**KIRKLEES METROPOLITAN COUNCIL  
INVESTMENT & REGENERATION SERVICE**

Reference No:	<b>2022/44/91704/W</b>
Site Address:	land at, Orchard Street West, Longwood, Huddersfield, HD3 4TE
Description:	Discharge conditions 8 (Ventilation Scheme), 9 (Acoustic Barrier), 12 (Boundary Treatment) on previous permission 2020/94342 for erection of 5 dwellings
Recommending Officer:	Katie Chew

## Officer Report

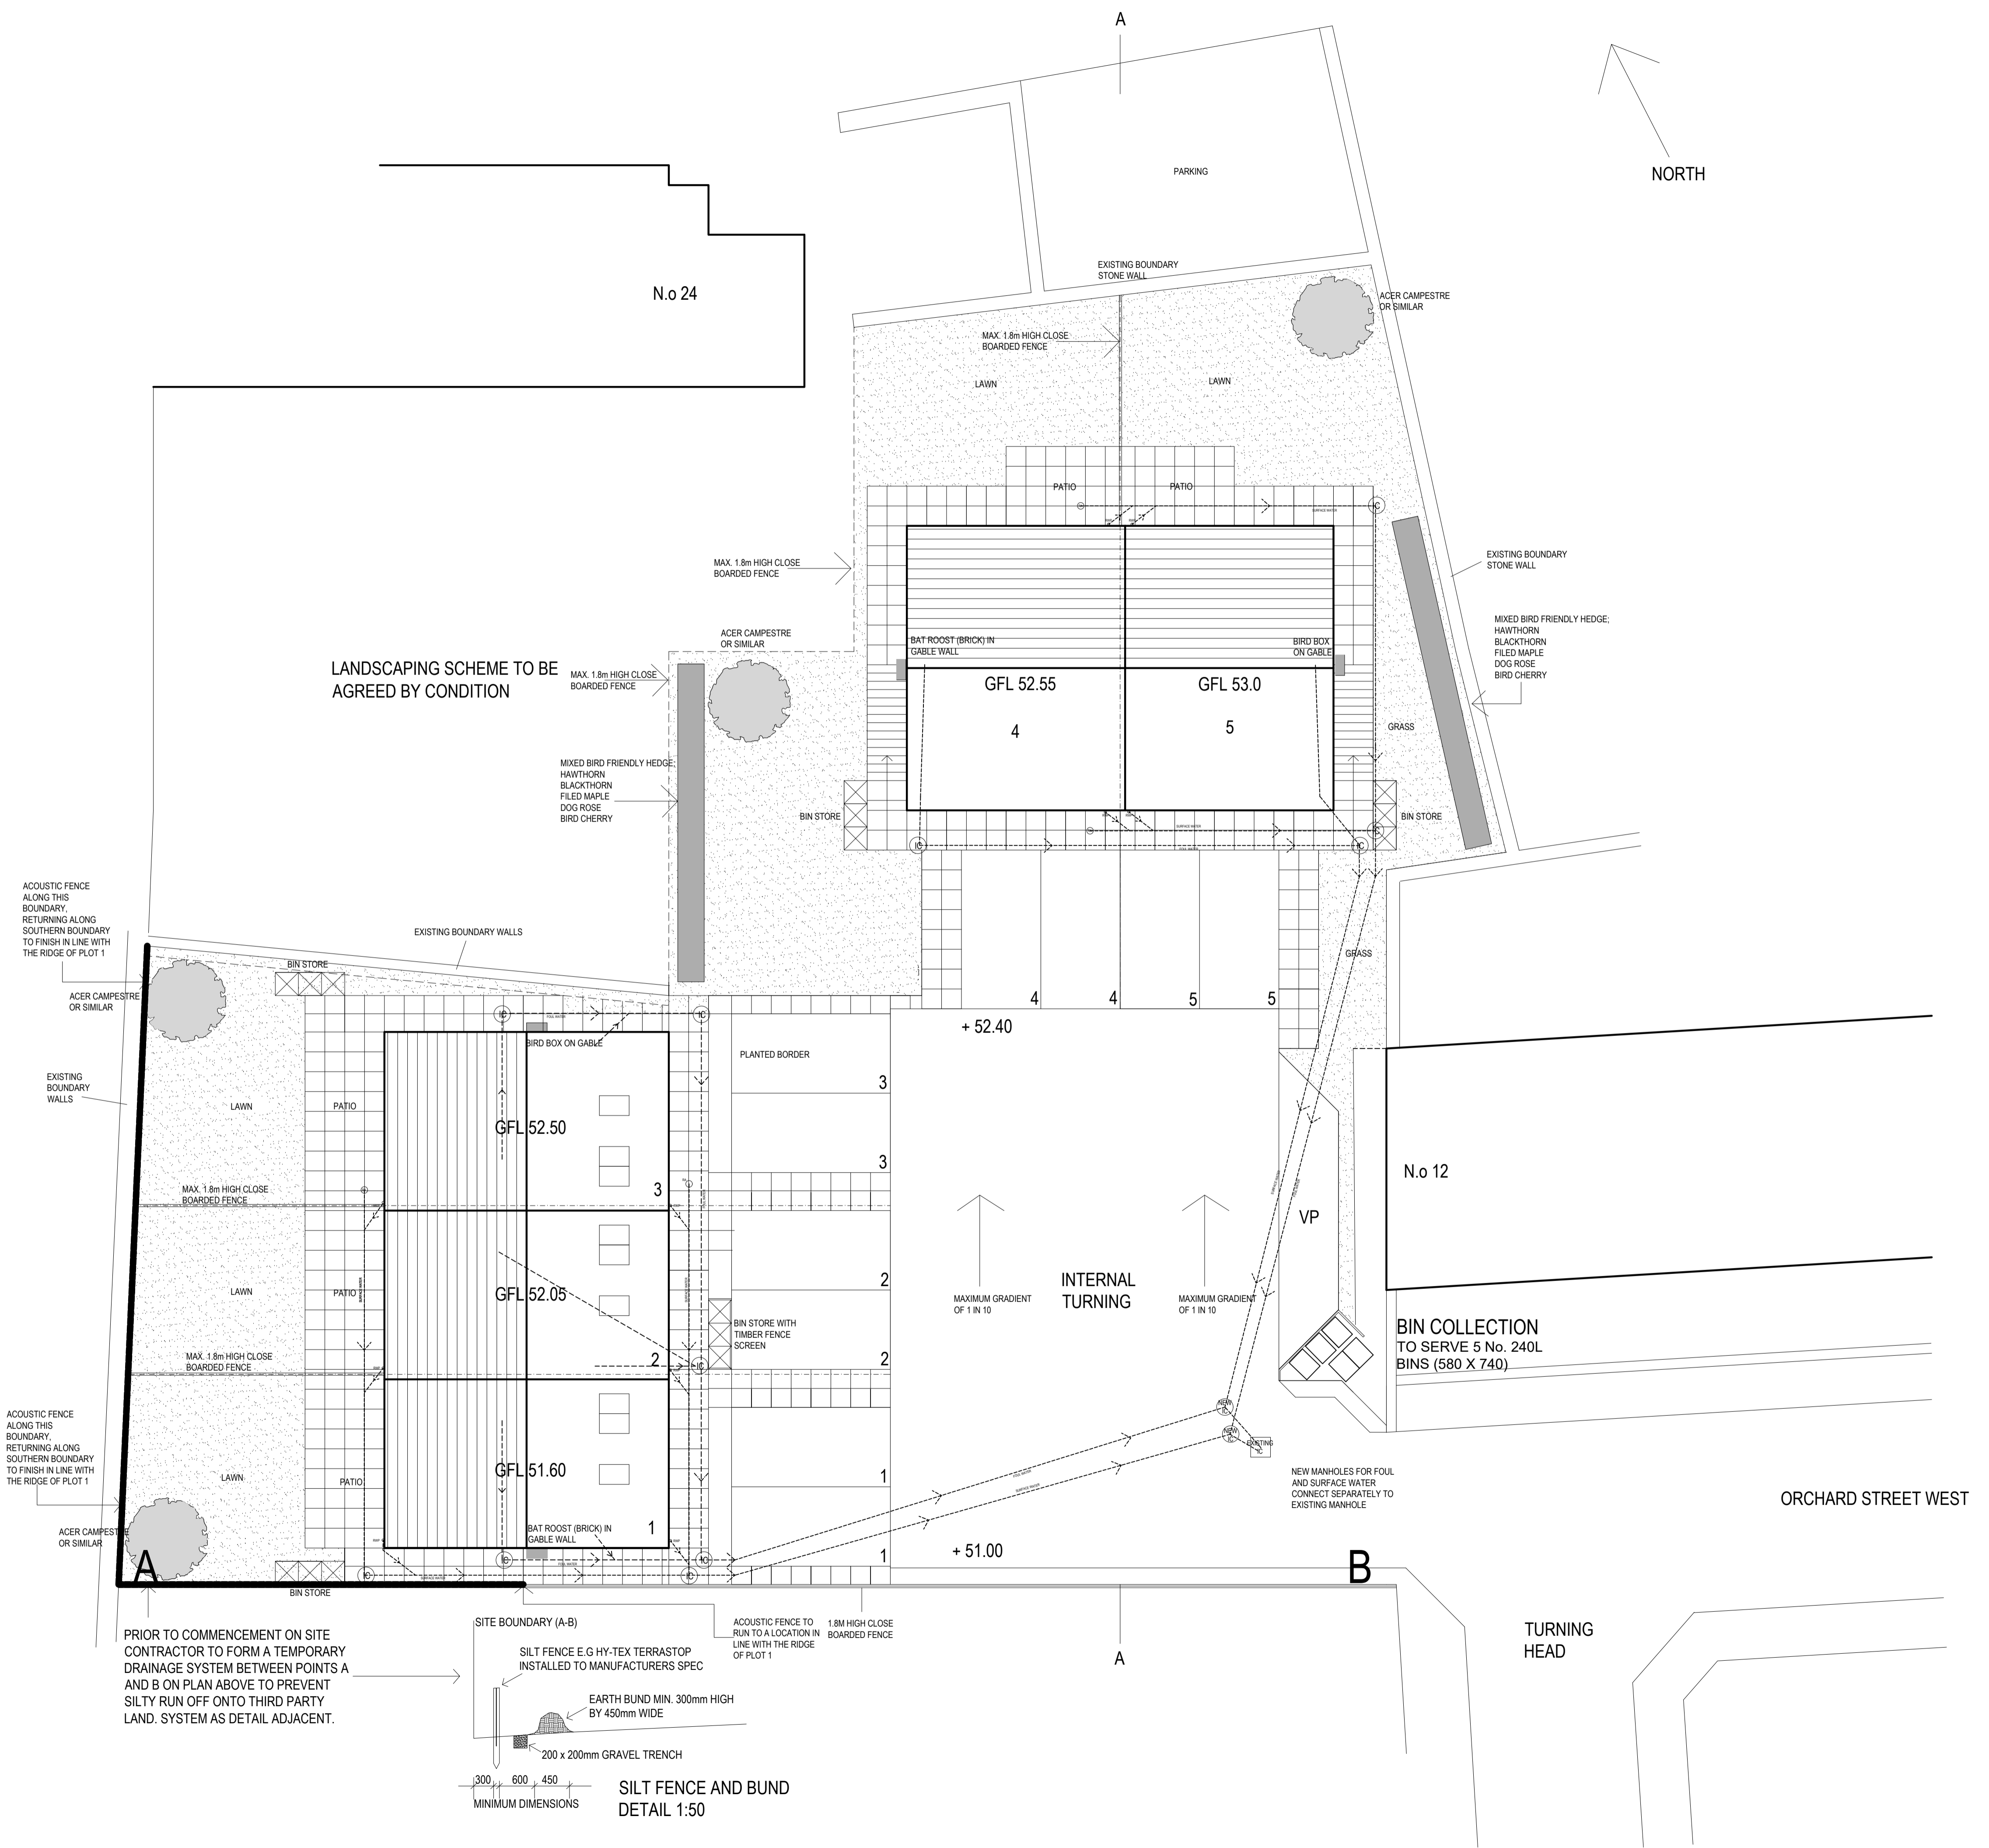
The agent has provided details of the Acoustic Barrier in both the submitted Detailed Site Plan – Drawing No. 01 Rev B, received 24<sup>th</sup> June 2022 and within the submitted an Assessment of the Acoustic Barrier authored by DRUK dated 02 May 2022 Ref DRUK/ACC/RS/OSWBA/3051, received by the Council on the 17<sup>th</sup> of May 2022.

The location of the acoustic barrier is also outlined within the submitted Detailed Site Plan – Drawing No. 01 Rev B, received 24<sup>th</sup> June 2022, and is to be located along the western boundary to the rear of Plots 1, 2 and 3 and the southern boundary of the rear garden of Plot 1. The acoustic barrier would be built from material with a mass of at least 10 - 15kg/m<sup>2</sup>. In this case, a robust close boarded timber fence.

The agent has provided details for the proposed boundary treatments within the submitted Detailed Site Plan – Drawing No. 01 Rev B, received 24<sup>th</sup> June 2022. New 1.8m high close boarded timber fences are to be provided along the south-western boundary of the site, in between gardens of Plots 1, 2, 3, 4 and 5, and along the north-western boundary of Plot 4. An acoustic barrier fence is to be provided along the western boundary to the rear of Plots 1, 2 and 3. Further details of this acoustic barrier can be found within the submitted Assessment of the Acoustic Barrier authored by DRUK dated 02 May 2022 Ref DRUK/ACC/RS/OSWBA/3051. All other boundary treatments within the site relate to existing boundary walls which are to be retained.

The proposed boundary treatments are considered to be suitable and sympathetic to the area, with other examples of close boarded timber fencing found within the immediate vicinity. The proposed boundary treatment is also considered to be suitable to protect the residential amenity of both existing residents and future occupiers of the dwellinghouses.

Therefore Condition 9 will be satisfied, provided that the acoustic barrier as specified in the submitted document and plan is constructed prior to the dwellings being first occupied and that once installed the acoustic barrier shall be retained thereafter.

Condition 12 will be satisfied provided the development is completed in accordance with the approved boundary treatment details before the dwellings are first occupied and thereafter retained.
